Planning Application 3/2020/1061
Pendle View, Primrose Lane, Mellor BB2 7EQ
Proposed Erection of a Seven Bedroom Holiday Cottage.

[REDACTED] I write to object against the above planning application
[REDACTED] I ask for the following to be taken into consideration:

Materials Key:

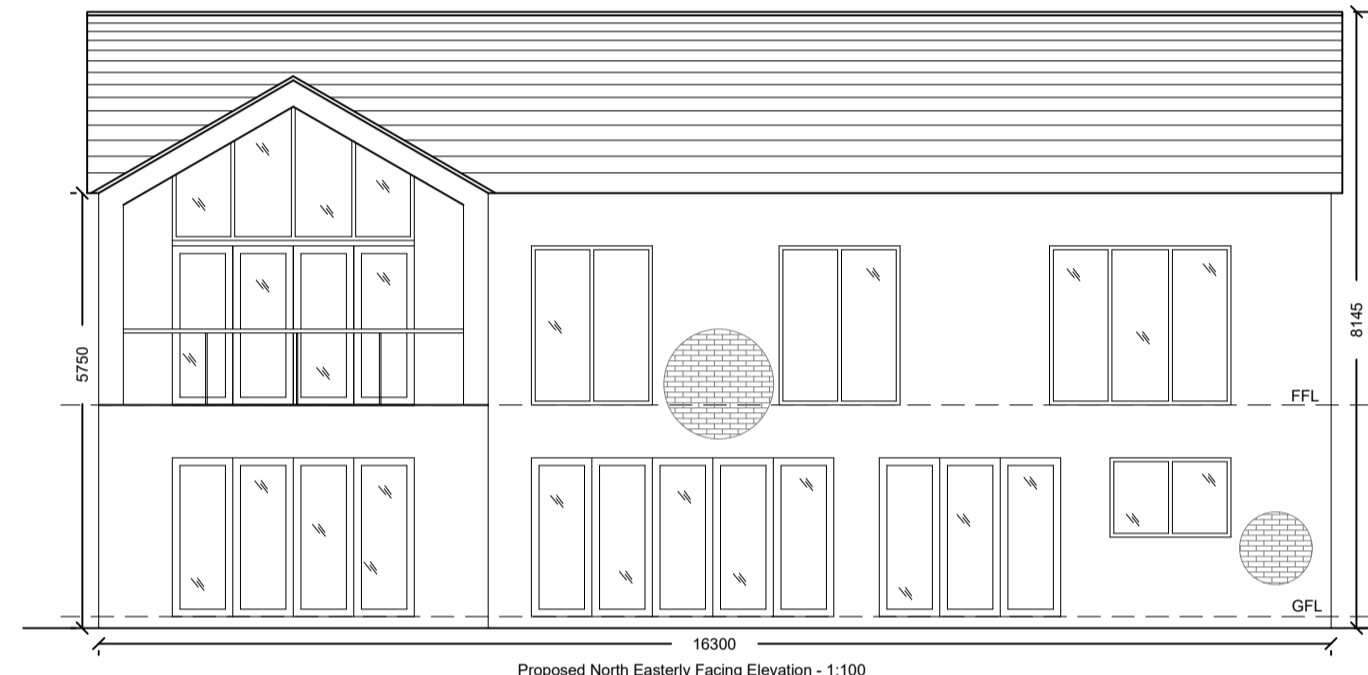
Visual Amenity. The design is not in keeping with the local area and will have a negative effect on the visual amenity. The property is to be constructed of brick, this is out of keeping with the present house on the applicants site Pendle View and the nearby properties of Lower Leaches Farm, Primrose Cottage and Mellor House, which are all constructed from stone. This proposal does not relate in design or use to the current buildings on site and in the neighbourhood and has no related benefits to the local settlements.
